**Consultation Response from Trees Planning,
 KC Trees**
**2019/92940 Land west of, Ashbrow Infant and Nursery School, Ashbrow Road, Ashbrow,
 Huddersfield**
**Erection of 161 residential units including a 50 unit extra care facility (all class C3) and public
 open space**
Date Responded: 07/10/19 Responding Officer: NG
Responding Ref: TPO 04/15

Appendix 1: Site Plan	
Ashbrow Road Huddersfield West Yorkshire HD2 1EX JCA Ref: 13945a/JB	21/08/18
NOT TO SCALE	
1	Stop location/number
SC1	Section location/number
	Transect route
	Trees
	Hedgerow
	Transect 1
	Transect 2
 Arboricultural & Forestry Consultants

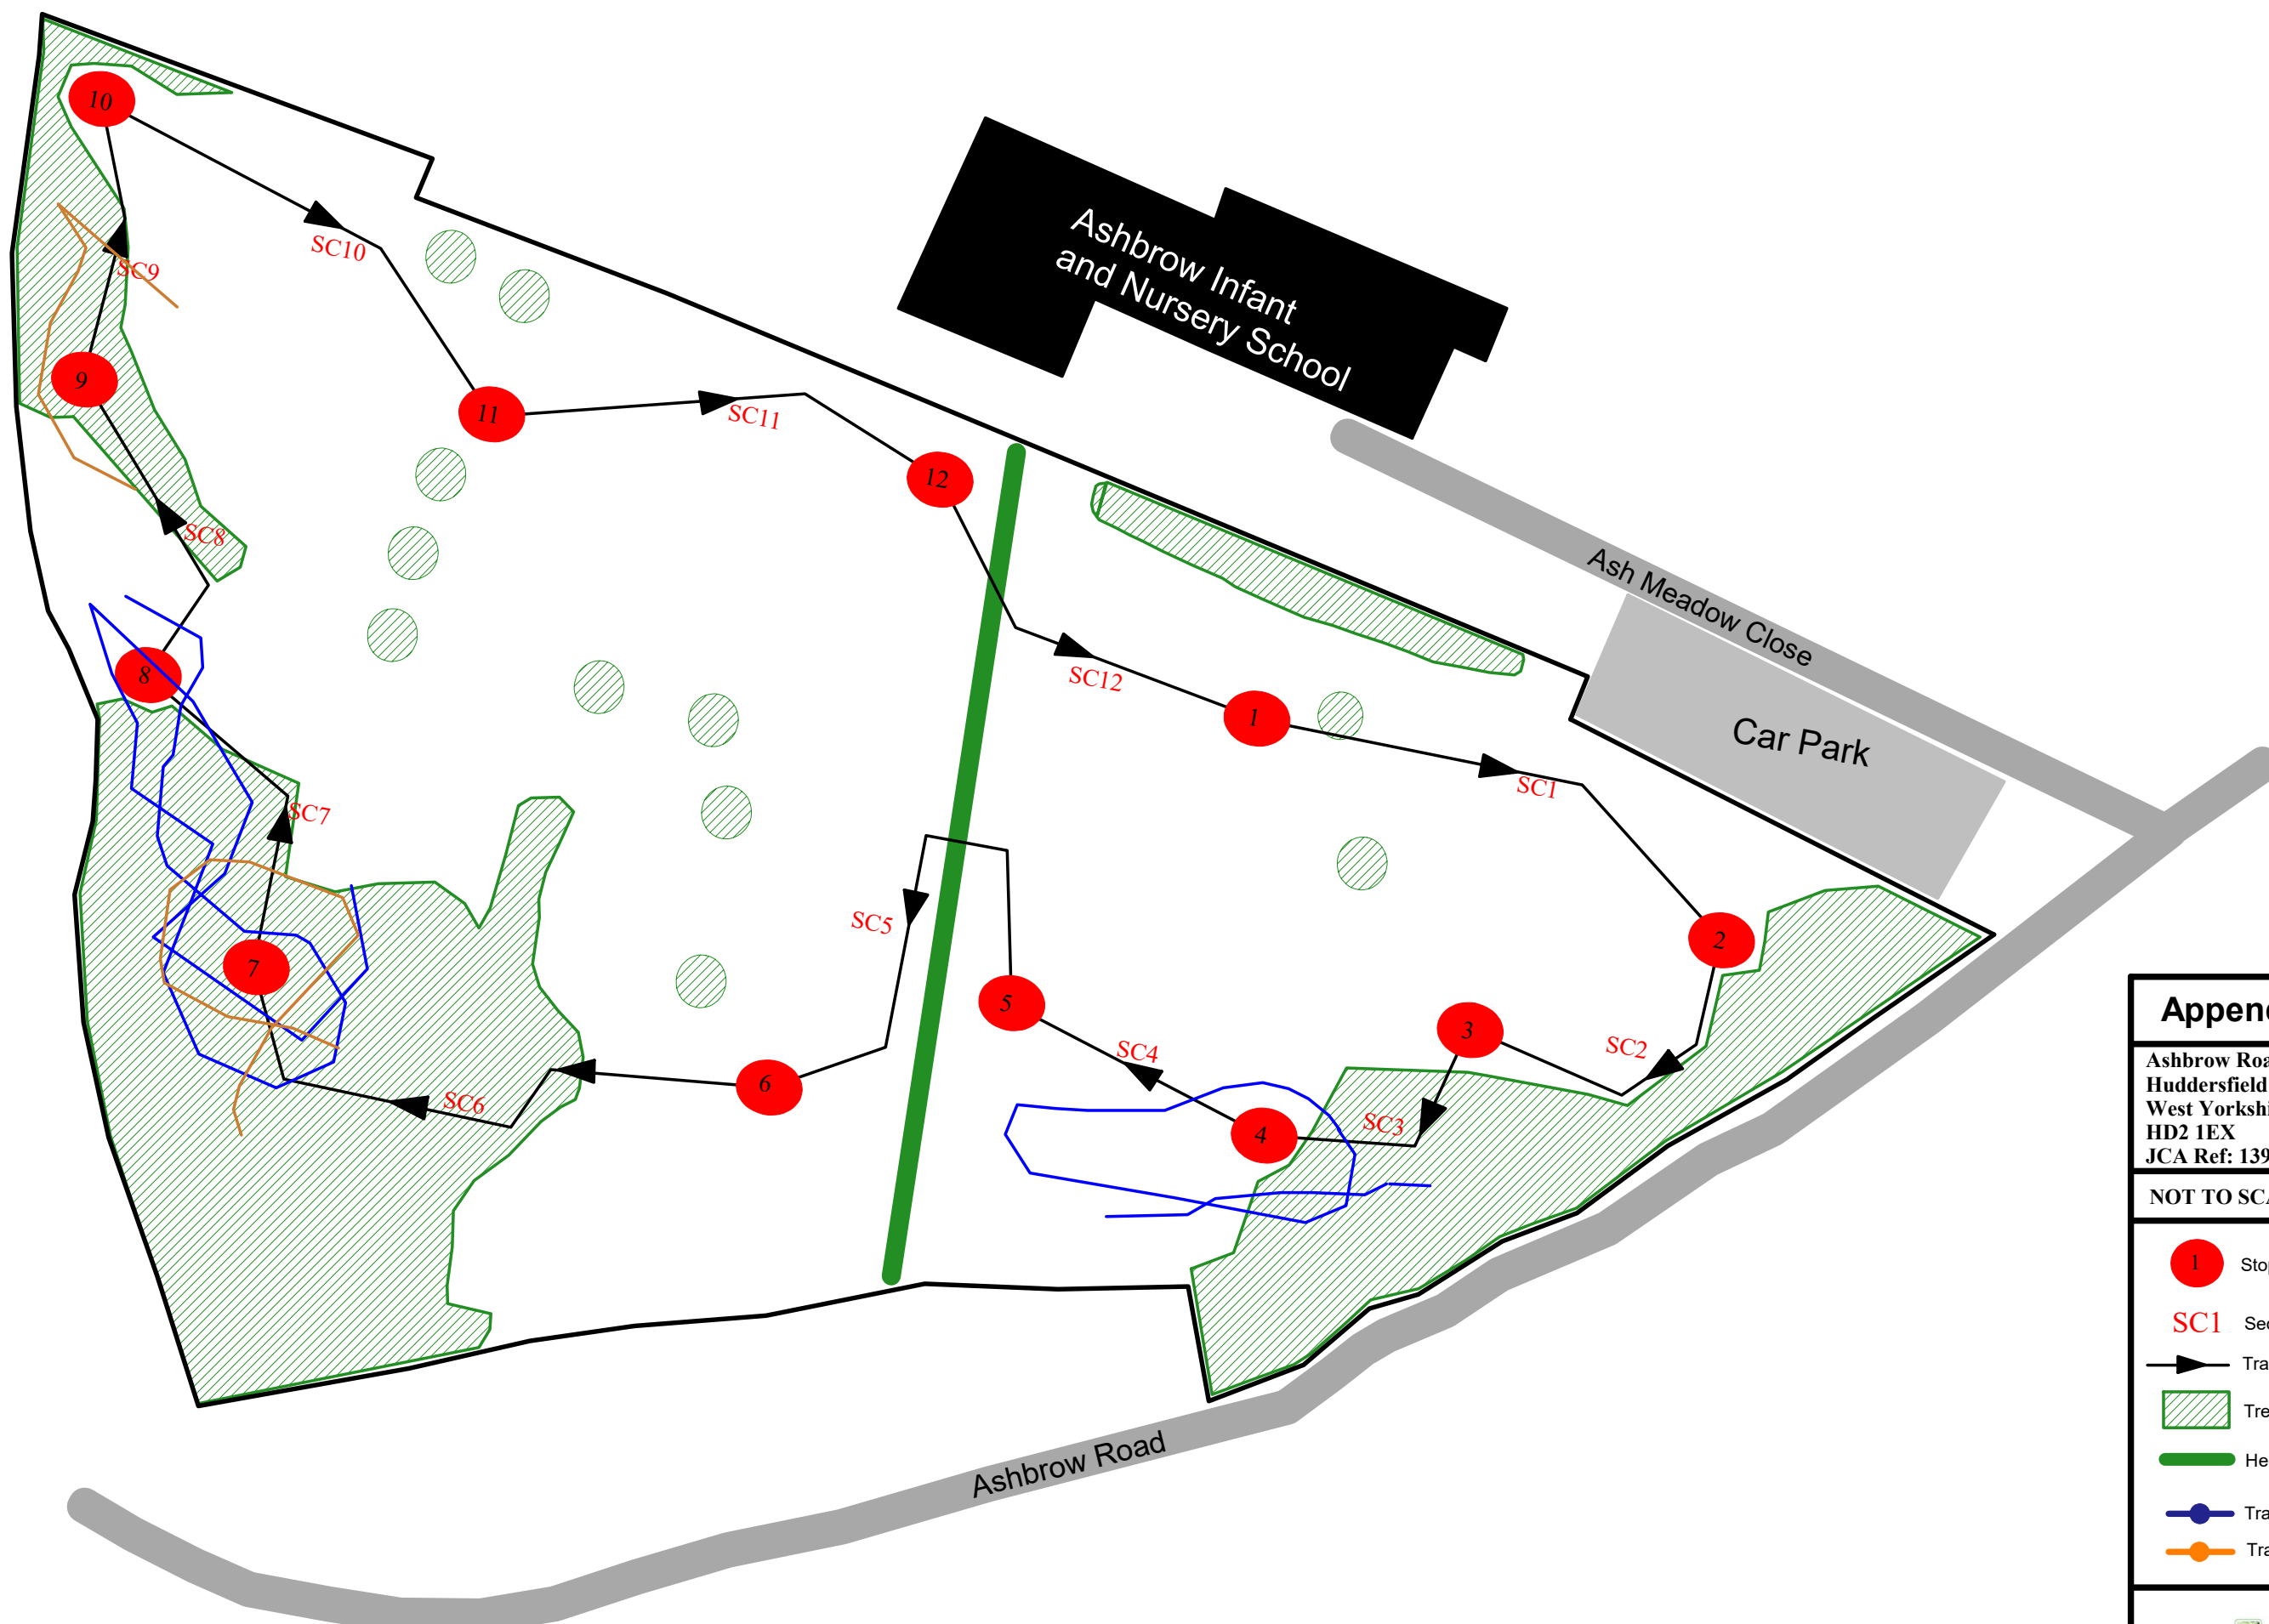
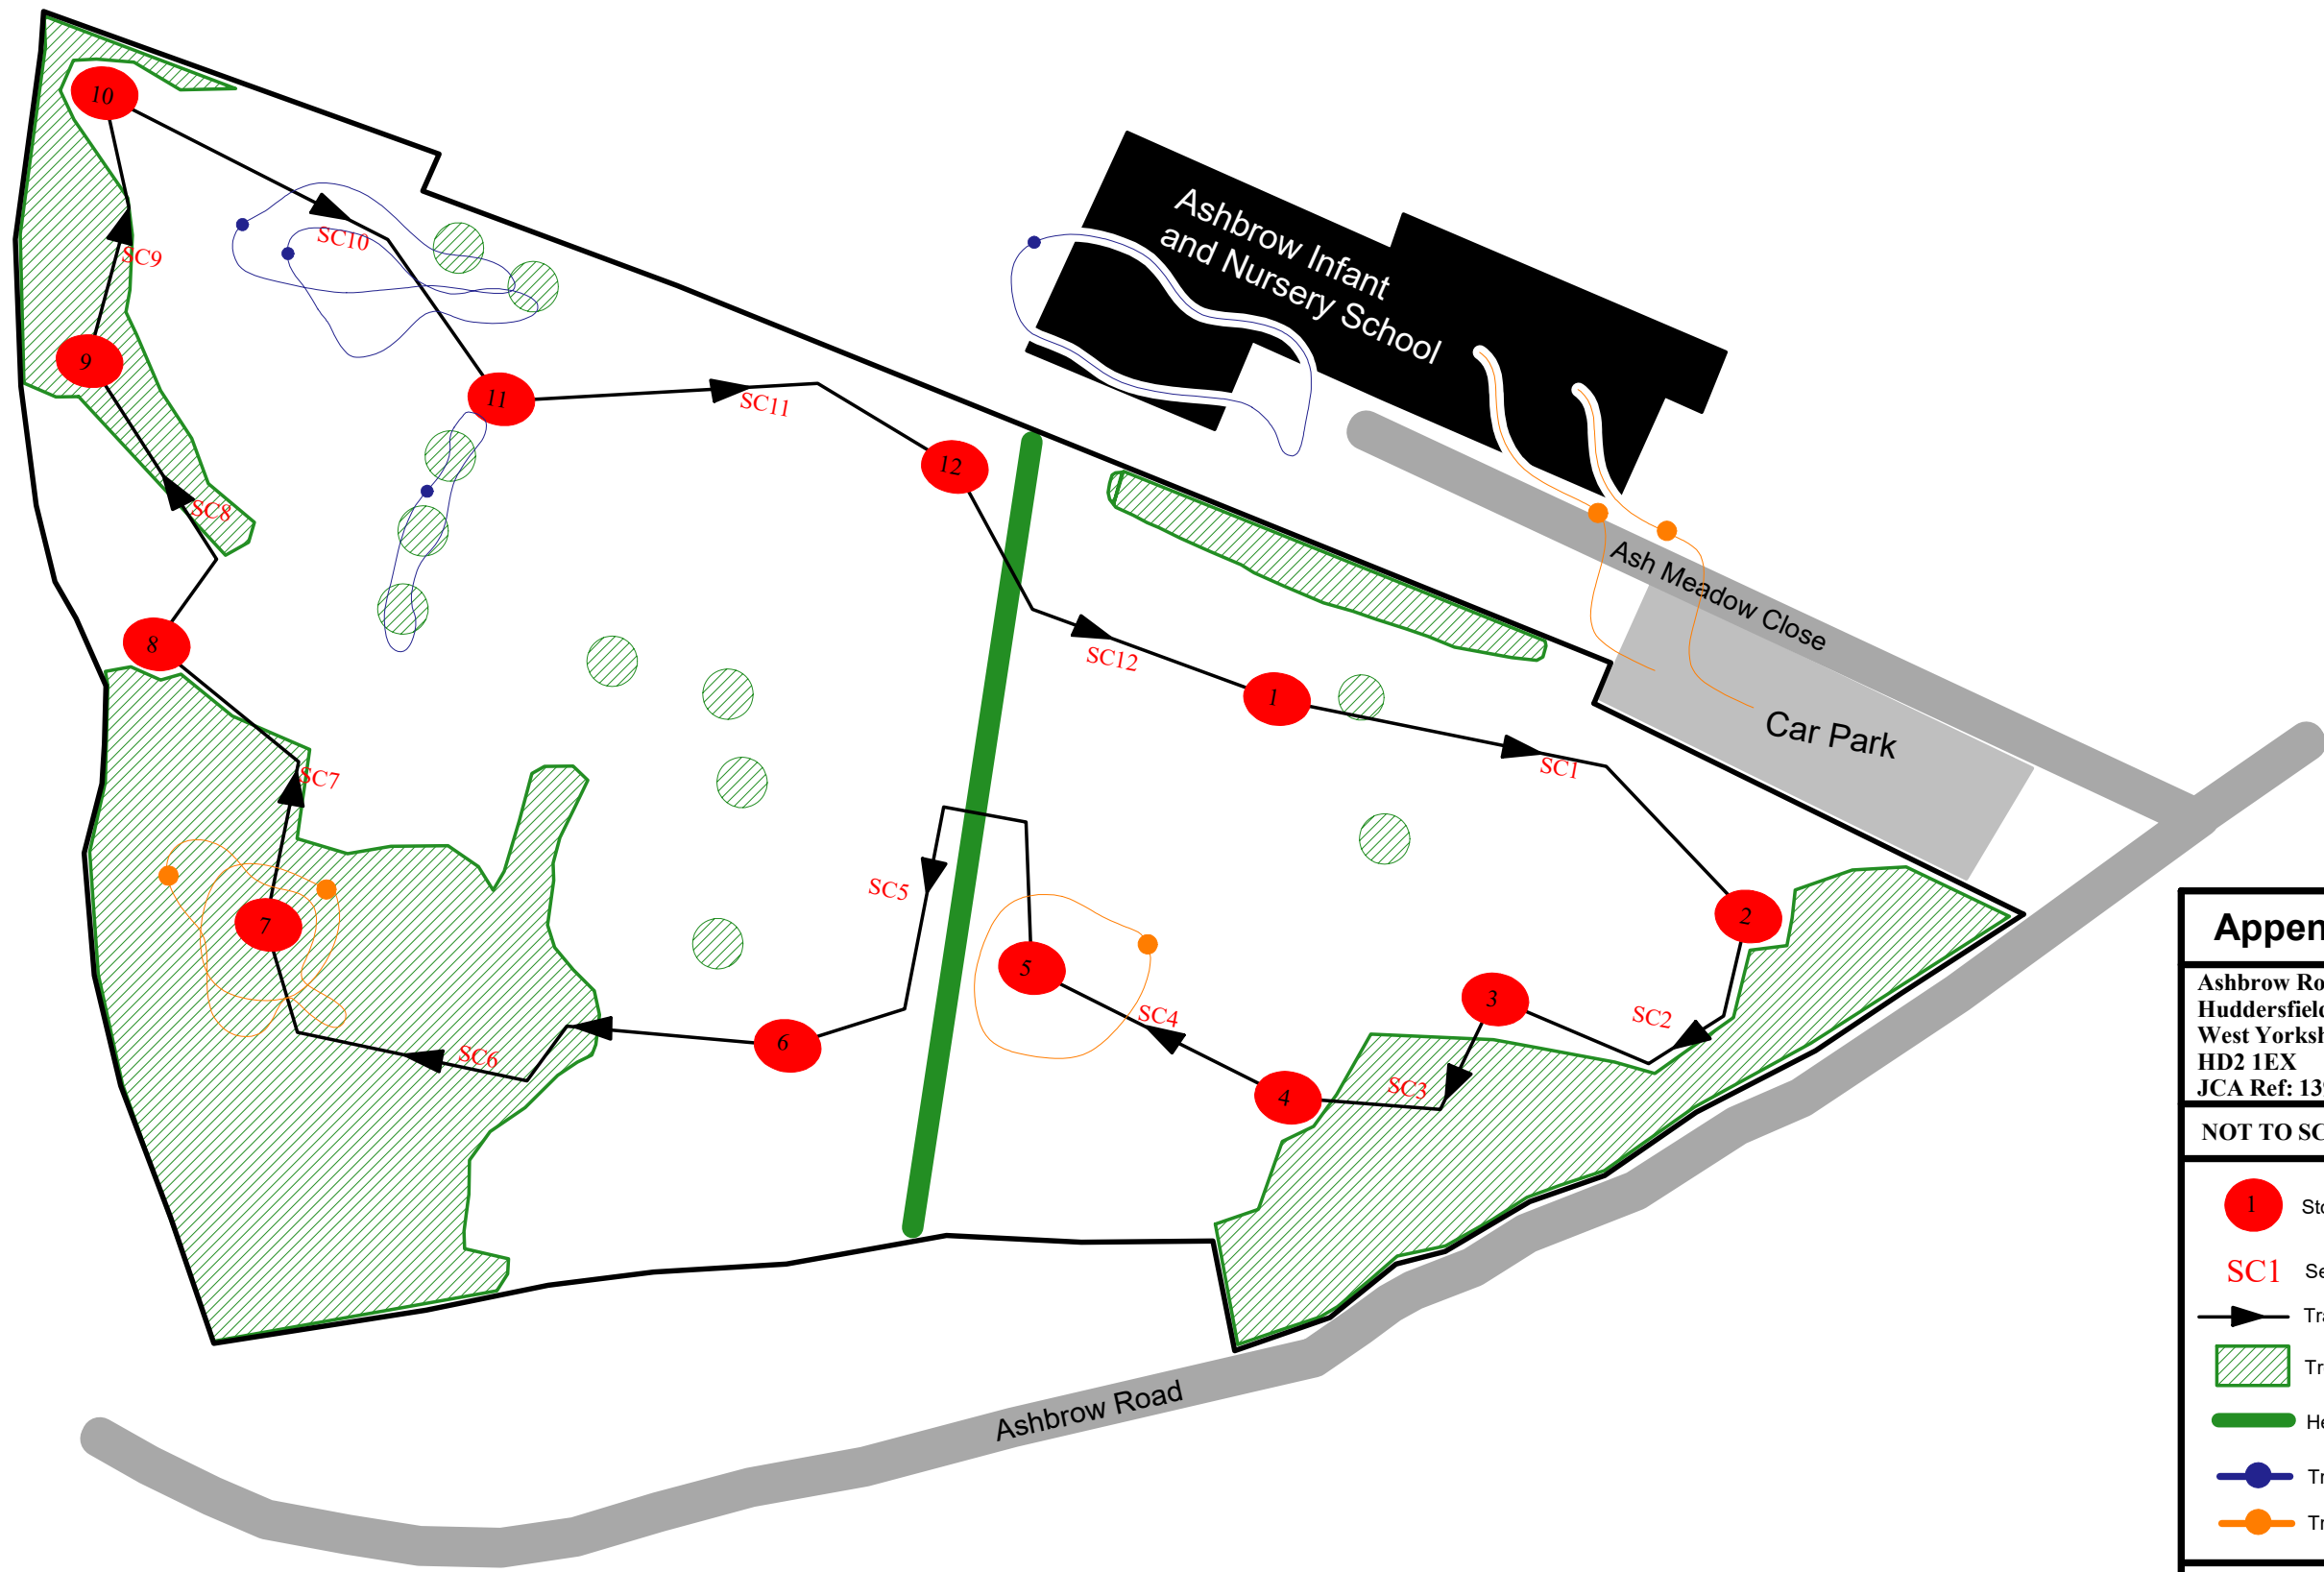
I have no objection to the proposals but am not satisfied with the tree information provided to identify which trees are to be retained and for managing the risk to those retained trees. The Arboricultural Impact Assessment Plan – Appendix F, does not accord with the submitted layout for the site and appears to require more trees than necessary to be removed. The tree removals identified on the Proposed Site Plan, A001 rev Y, are acceptable.

As such I would not want the submitted arboricultural information to be included with the approved documents as they need updating. In order to avoid holding up the application a condition for a site specific Arboricultural Method Statement and Tree Protection Plan, in accordance with BS 5837 could be added to any approval of this proposals.
